**Re: Application for non-material amendment to Planning Permission S6/2006/137/FP**  
**Property: 40 The Ridgeway, Cuffley, HERTS EN6 4BA**

Your letter states that you wish to make a non-material amendment to Planning Permission S6/2006/137/FP which was granted for the demolition of the existing garage and erection of a double garage with store room over and glazed link to existing dwelling and erection of new front entrance gates. It is noted that the application seeks to increase the length of the approved garage structure by 1m on the front elevation of the property as shown on Plan no. 6792/P/150, revision D received and dated 20 October 2009.

Project Birchwood
40 Ridgeway
Cuffley
Drawing Proposed Garage

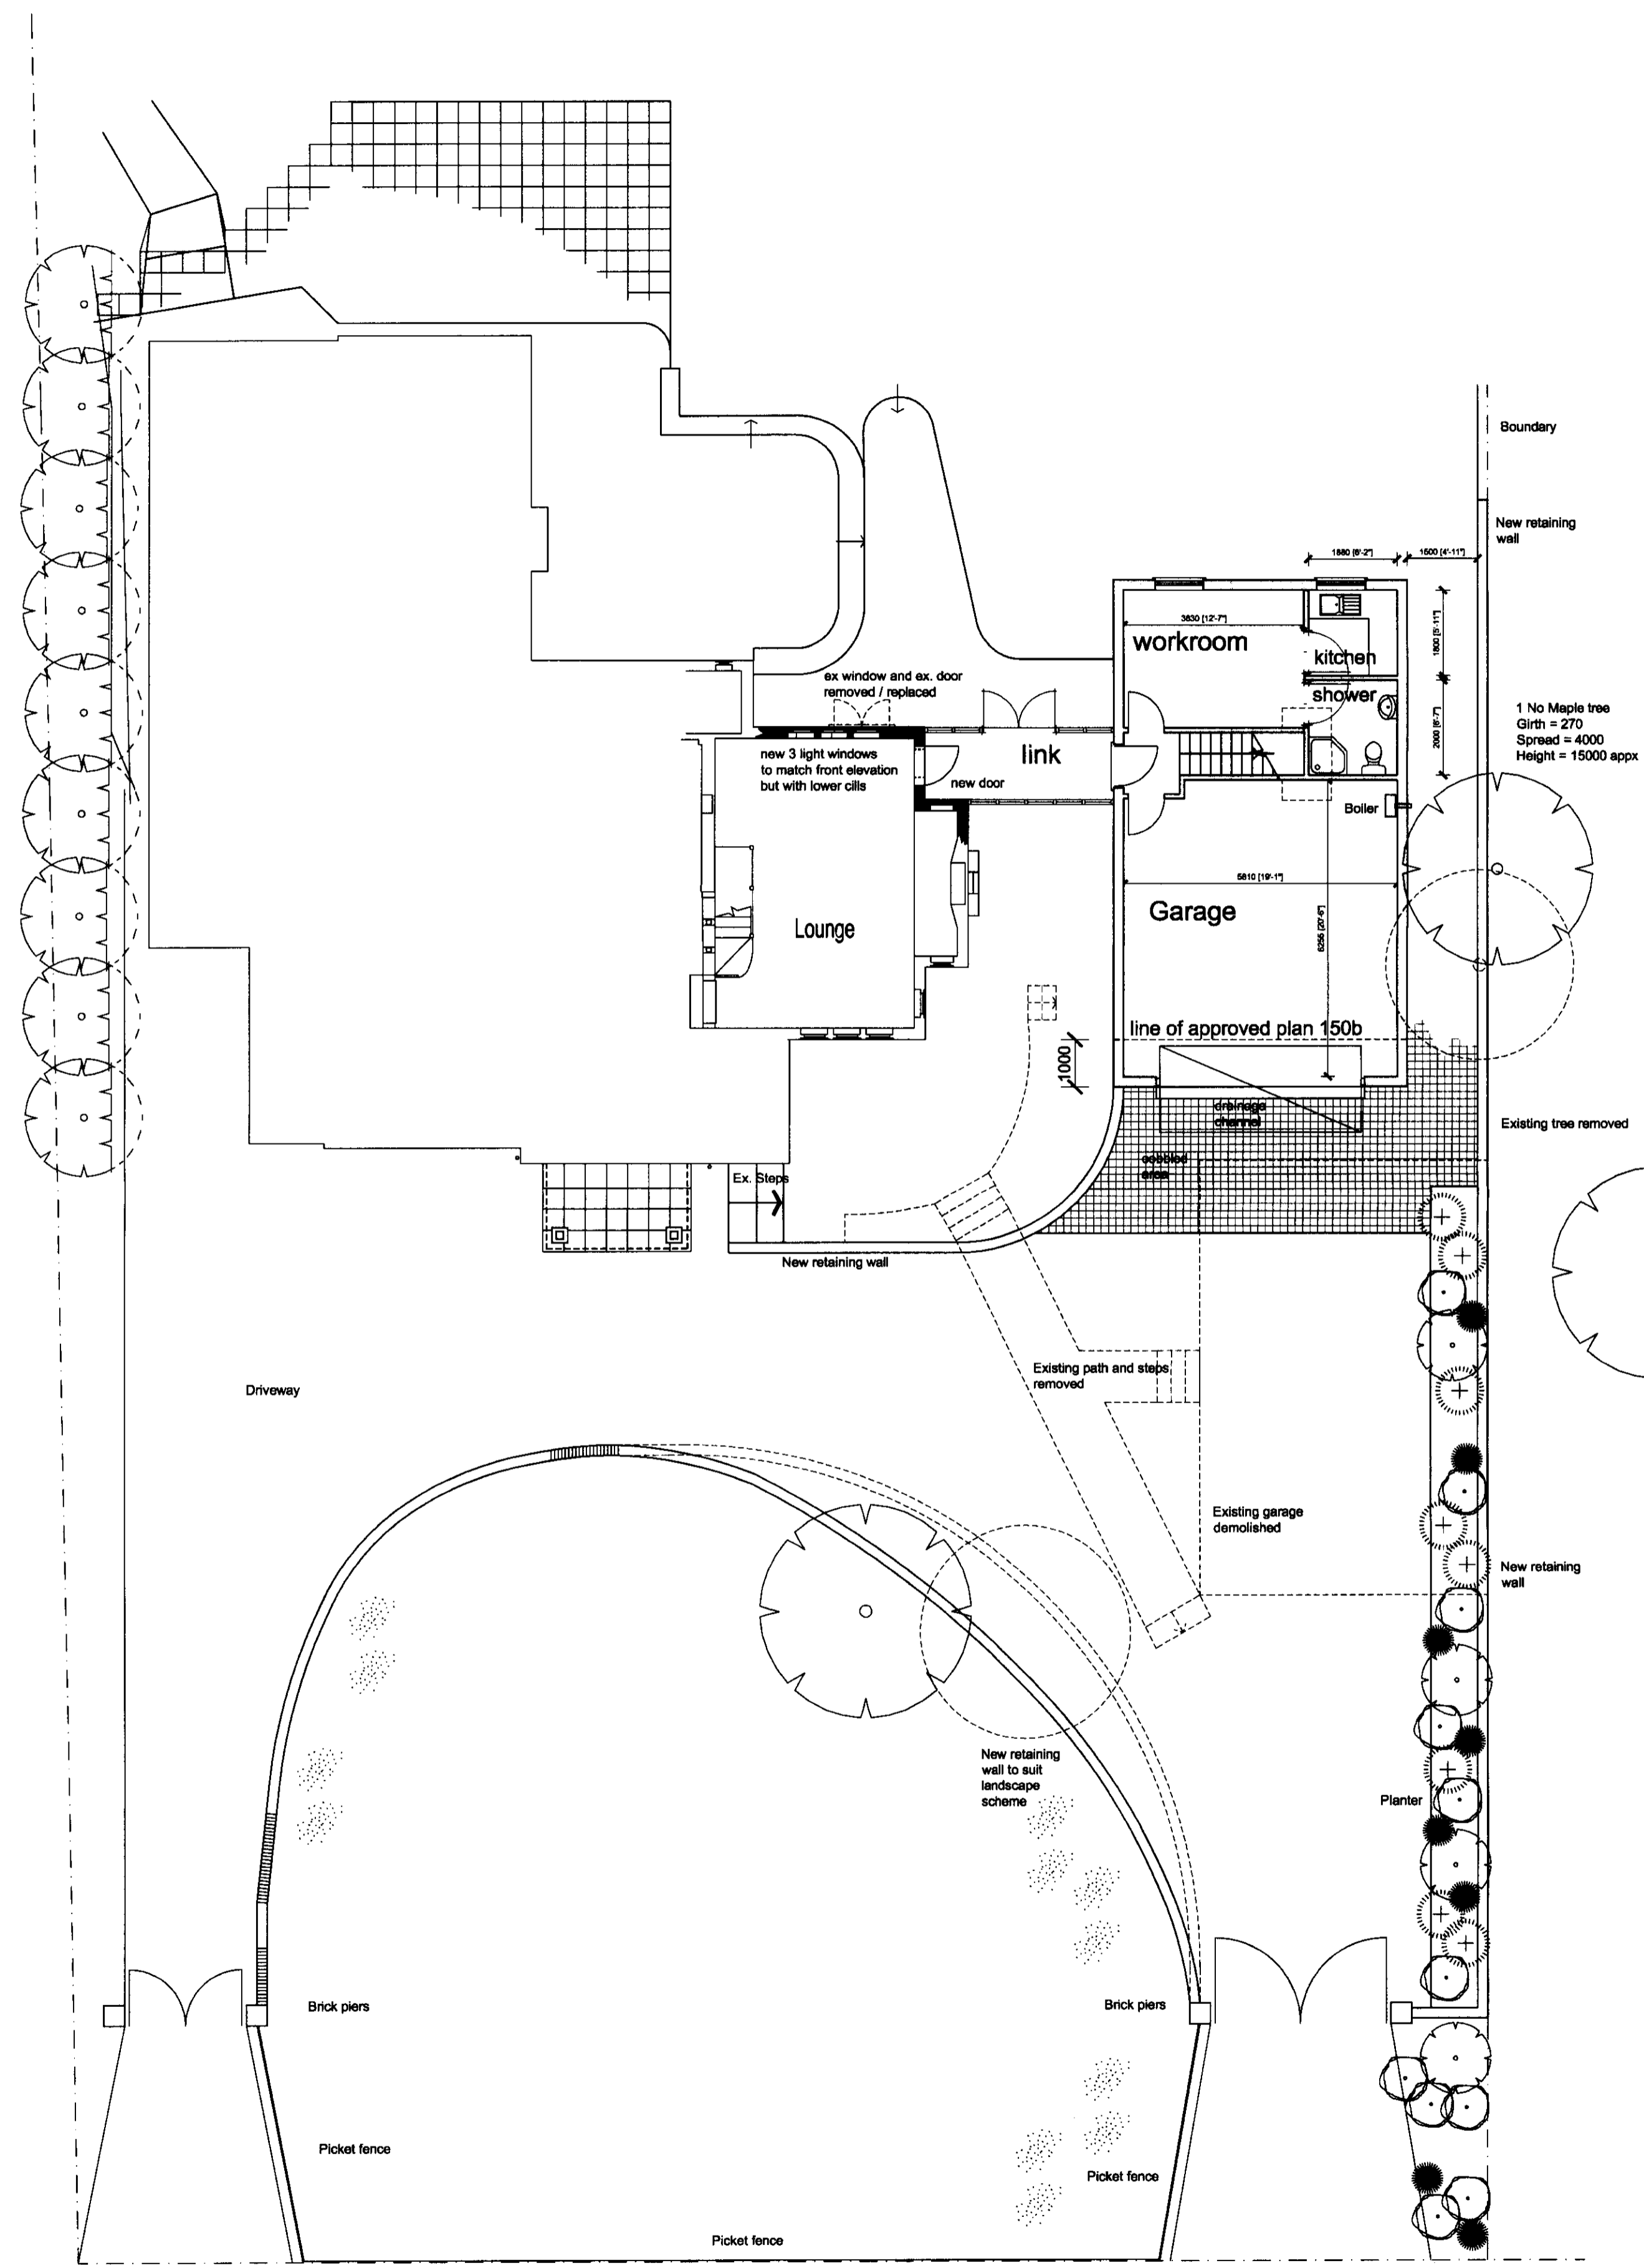
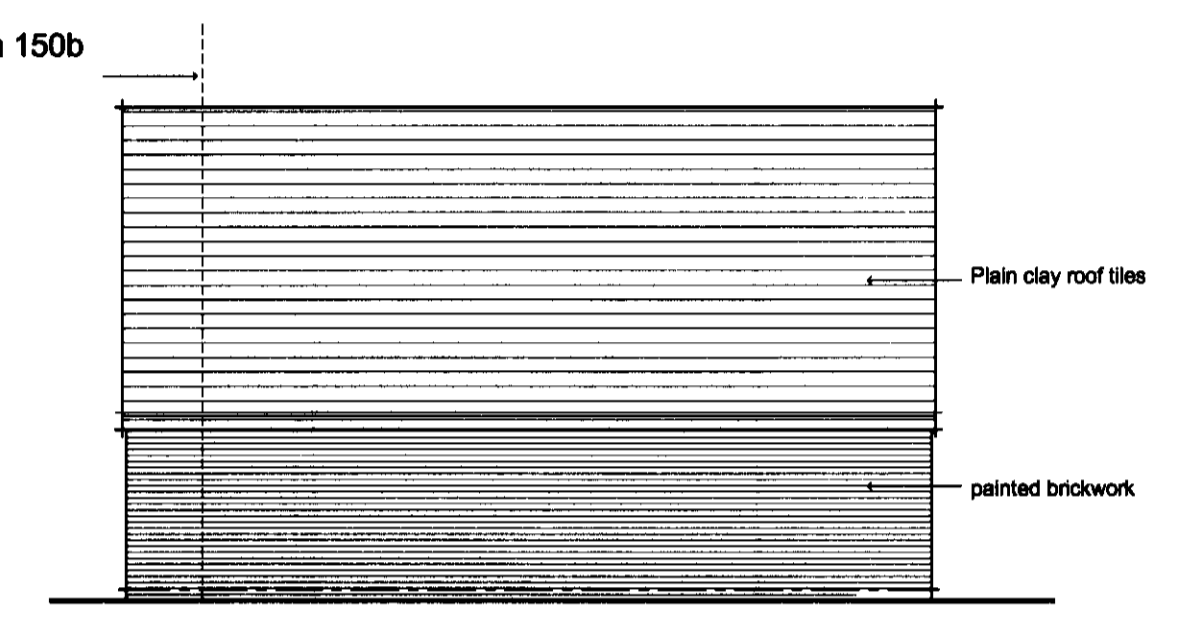
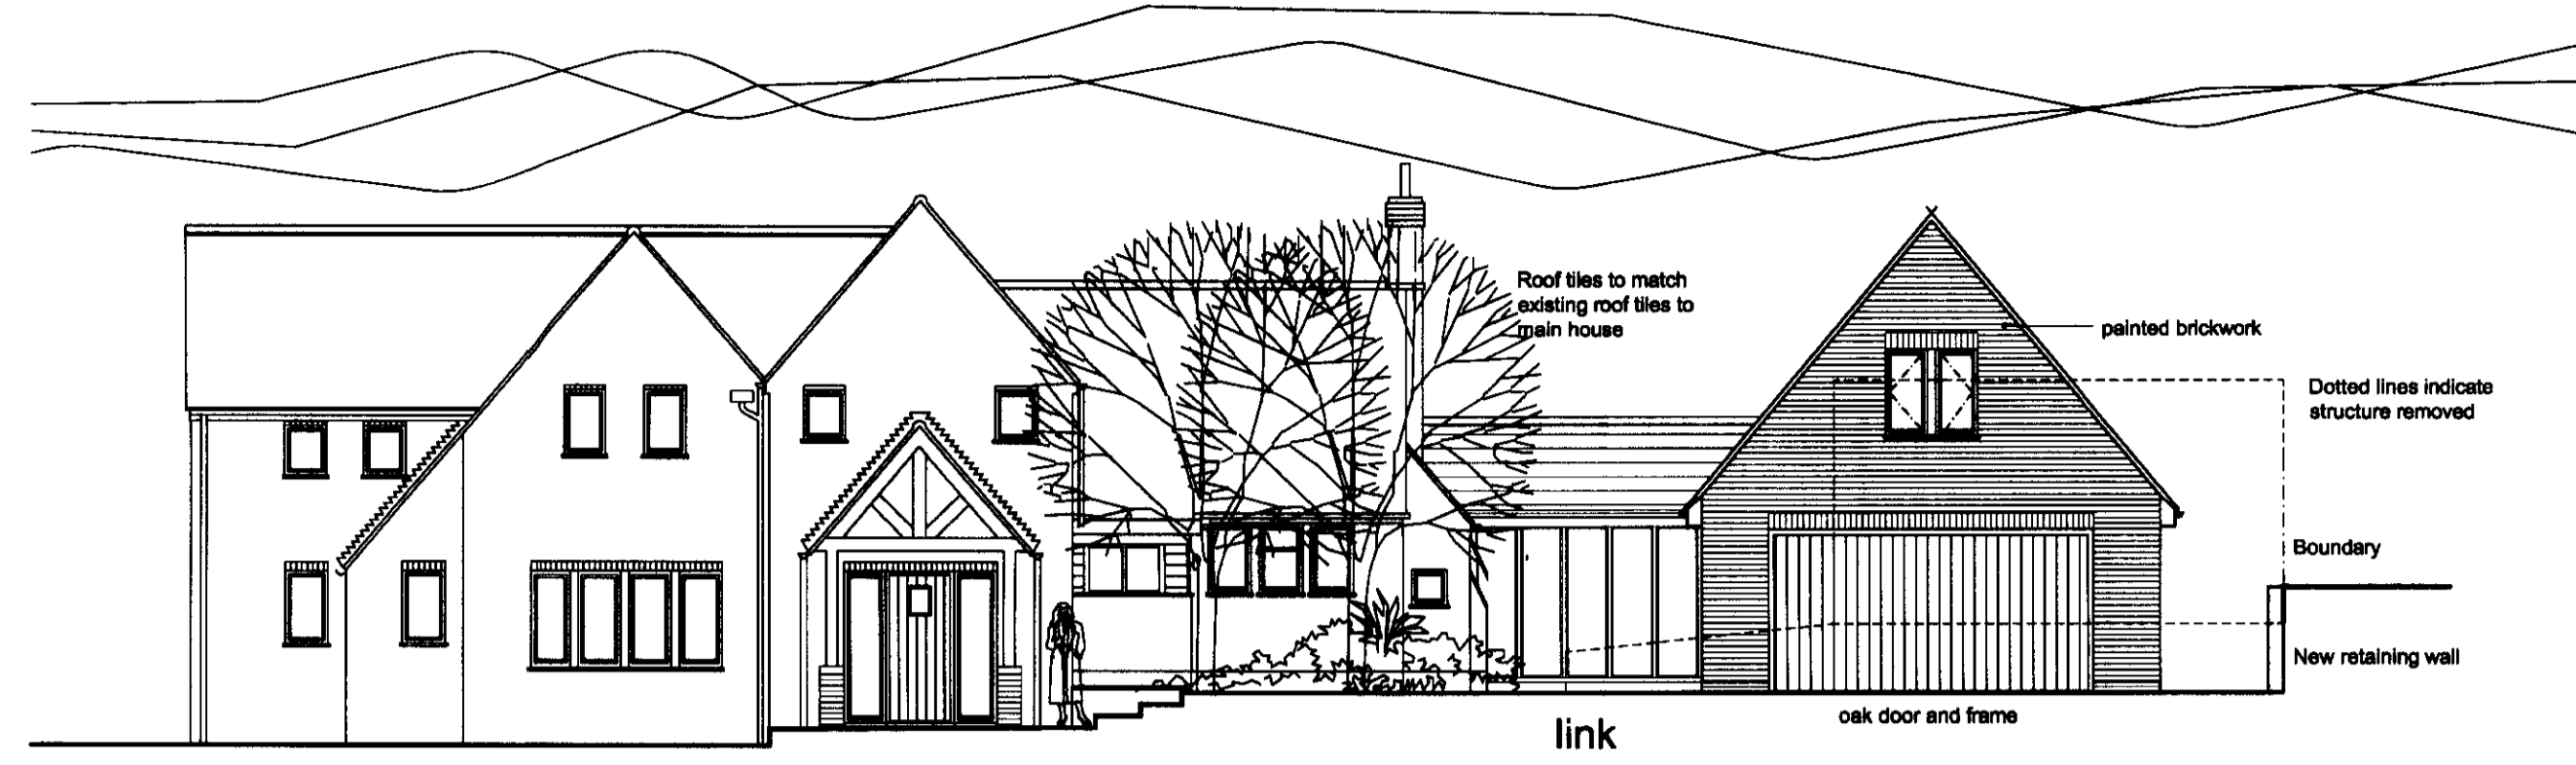
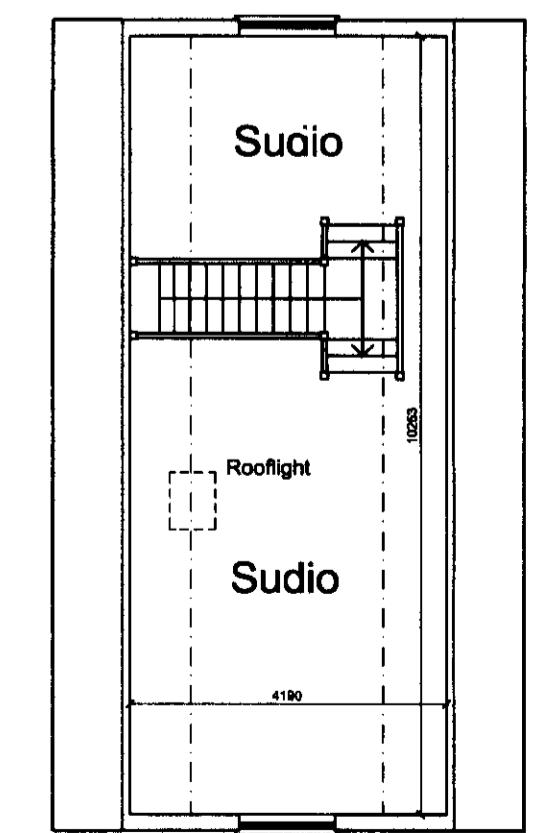
In this regard, it is considered that the above garage extension is not considered to be a non-material amendment and therefore the application is subsequently refused.

In addition, it is considered that the above amendment would not be considered a minor material amendment and subsequently a formal planning application would be required to be submitted for assessment. It is considered however that the proposal would not be in accordance with Council's policies and Planning Guidance 2: Green Belts given the area of extensions already permitted on site and Council would be unlikely to support the application.
